City of
Doncaster
Council

Deadline 5 Submission

Project: Tween Bridge Solar Farm (EN010148)

4th August 2026

Drawing file: published-documents / EN010148-000871-6.4.6.2 Environmental Statement Figure 6.2 Landscape Character Areas (Rev 2).pdf

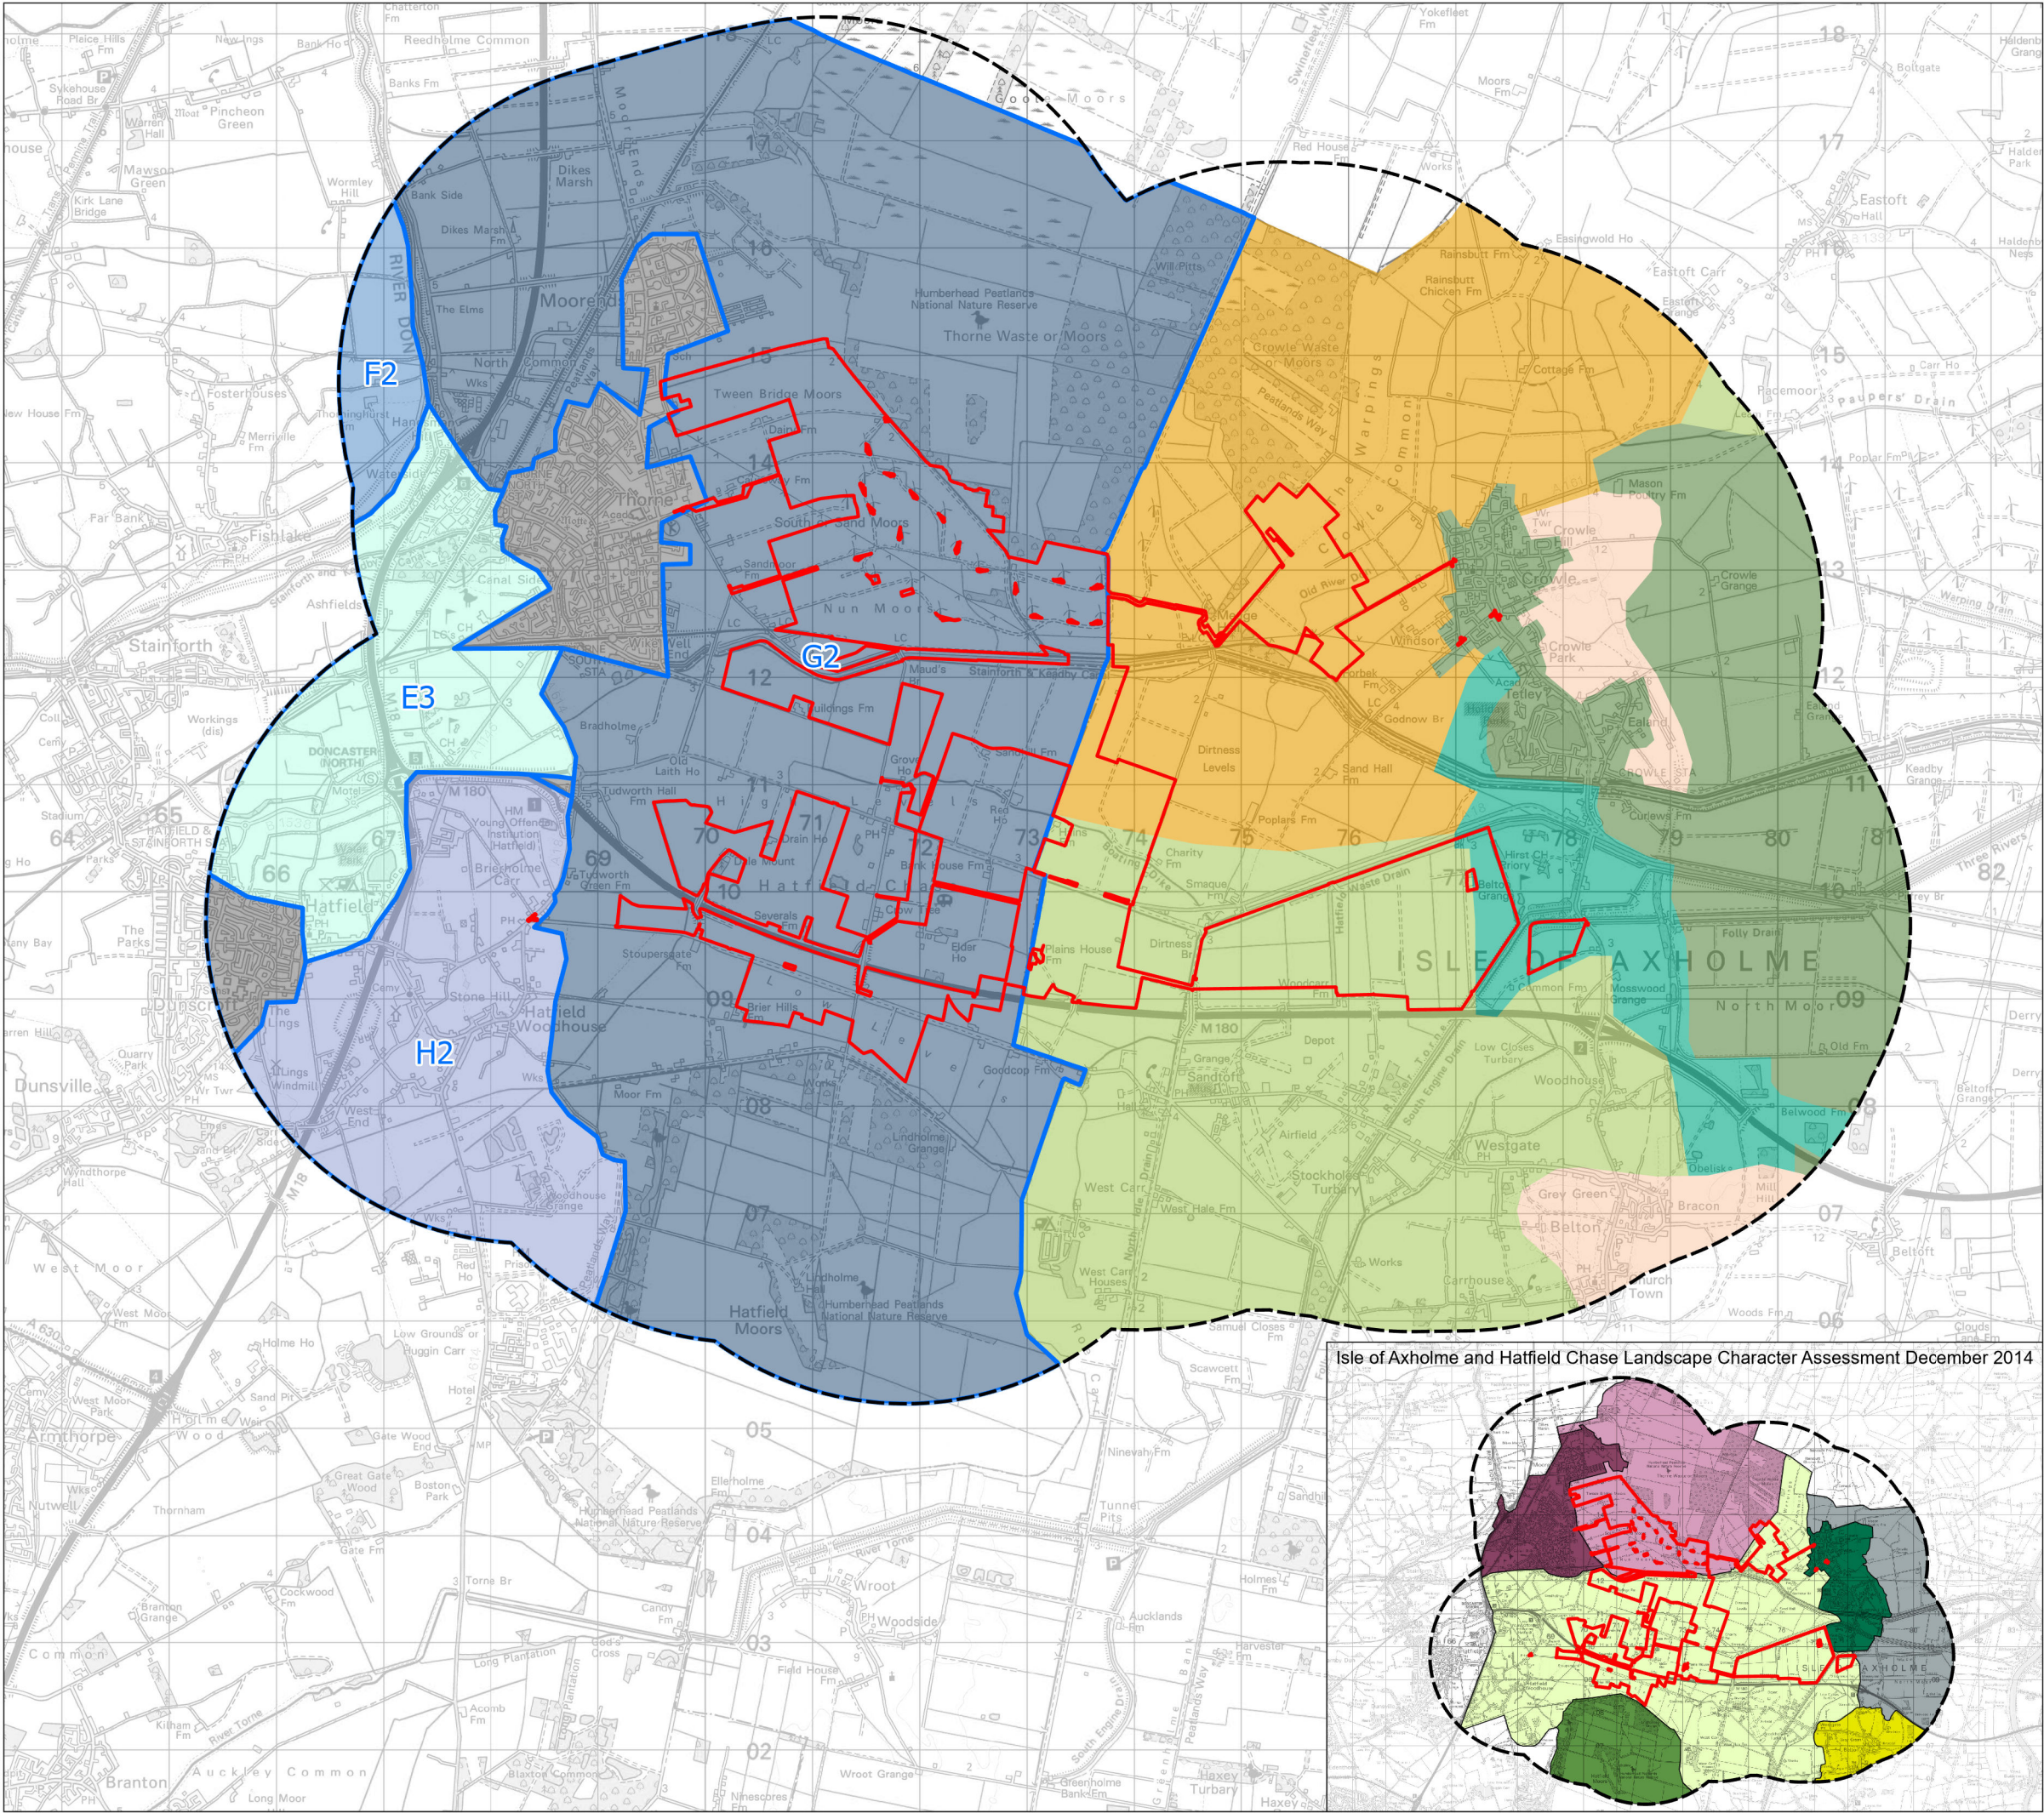
- 3.2 CDC notes that the land and visual impact assessment (LVIA) set out in 6.2.6 Environmental Statement Chapter 6 Landscape and Visual (Clean) (Rev 4) [REP4-021] has been updated to include sections on the two more recent character assessments (as requested) and the value of the landscape outside national designations in accordance with the Landscape Institute's Technical Guidance Note 02/21 Assessing landscape value outside national designations (TGN02-21)¹. The CDC has only had limited opportunity to review this, but from what has briefly been reviewed, it would continue to make the point that the landscape character has been under valued and underplayed in the LVIA.

- 3.3 Within the LVIA, baseline information has been added and then a statement on the susceptibility, value and sensitivity for these additional character areas made. However, no explanation is included on how the conclusion on value, susceptibility and sensitivity has been made. All the character areas added have been given a medium value, medium susceptibility to the development and medium sensitivity.

- 3.4 For example, Hatfield Chase Levels LCA (from the 2014 character assessment) is summed up in LVIA paragraph 6.4.51 [REP4-021] stating that the 'Hatfield Chase Levels LCA is considered to be of medium sensitivity based on medium susceptibility and medium value'. The description prior to this statement, extracted from the LCA text, includes the bullet points – 'Important historic landscape', 'rare historical settlement pattern'; 'strongly geometric landscape, dominated by big skies with a marked sense of space'. CDC considers that it is difficult to see how an area with that description would not be considered high value. It also does not understand why it would not have a high susceptibility to the type of development proposed when a large portion of the proposals lie within it. This would result in a high sensitivity.

- 3.5 Similarly, in relation to the Trent Levels – flat Open Remote Farmland (in the NLC study) includes key characteristics including 'the landscape has been

described as remote, although this now feels to have been eroded due to the significant vertical intrusion of the windfarm to the west of Medge Hill'. This CDC considers demonstrates that the landscape is already under pressure and changing as a result of development, so a solar development would add to this pressure, meaning the landscape is highly susceptible (not medium).

- 3.6 And in relation to the Thorne and Crowle Moors (2014 LCA) they are described as 'internationally designated for their important raised bog habitats', 'one of the largest lowland raised bogs in Britain', 'remote, peaceful and largely inaccessible' but are summed up in the LVIA as being of medium value, medium susceptibility, medium sensitivity.

- 3.7 Other character areas have been addressed in a similar manner with medium value, medium susceptibility and medium sensitivity being the default for all character area added.
